Re: Status of Improvement Permit Application #05-5-11910

On May 11, 2005, an Environmental Health Specialist from the Harnett County Health Department attempted to evaluate your property for the purpose of issuing an Improvement Permit. This individual was unable to evaluate your property for one or more of the following reasons.

*Revised*

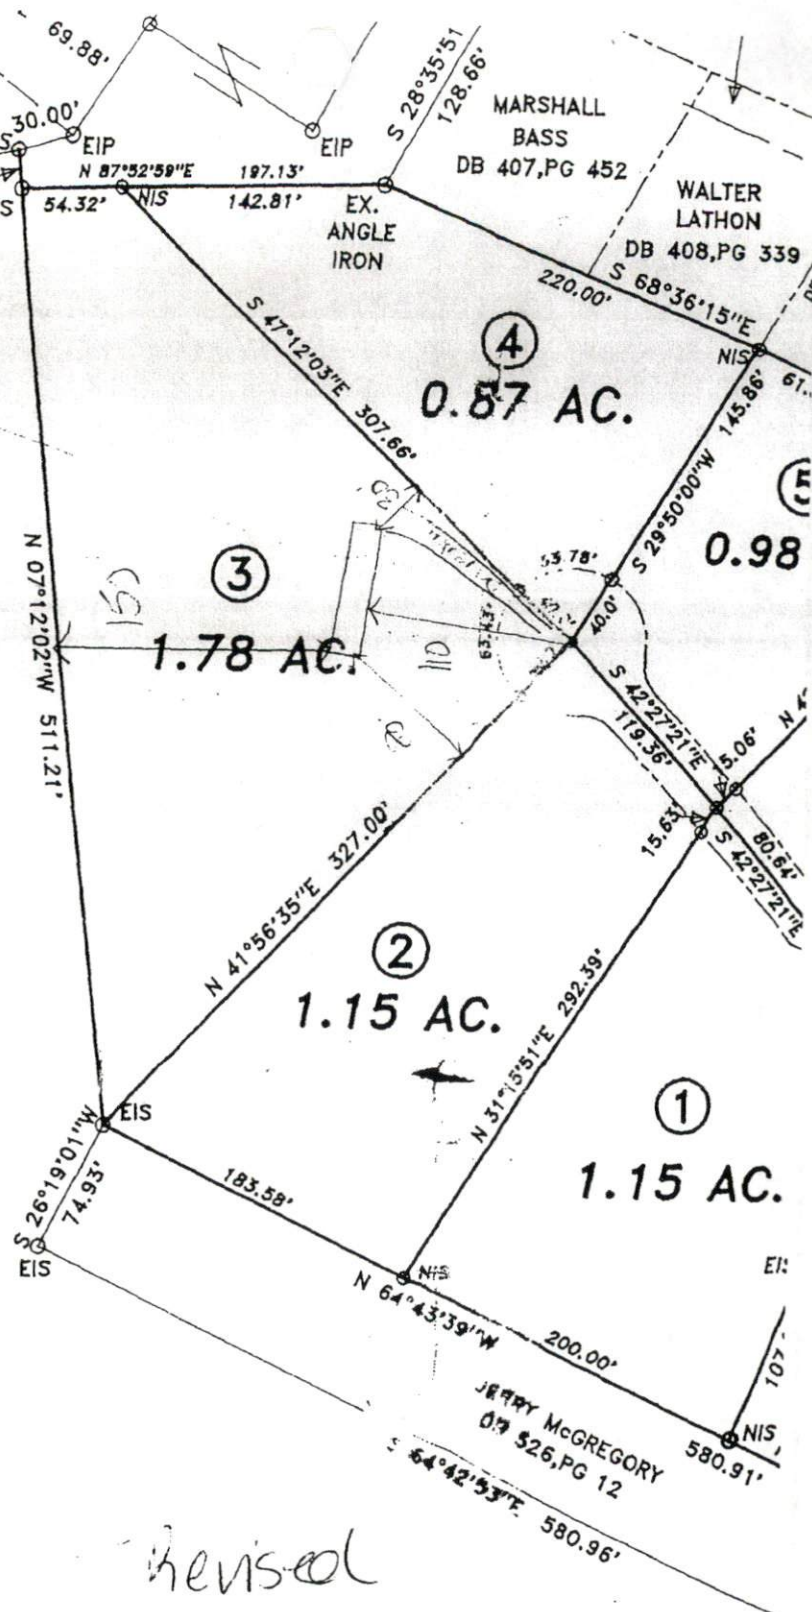
- 1. Property lines/corners not marked or labeled
- 2. House corners not marked or labeled
- 3. Directions not clear to property
- 4. Property needs brush or vegetation removed
- 5. Backhoe pits required
- 6. Other Home must be as shown on your consultant's map. Please submit new plot plan to Central Permitting. (see attached copy)
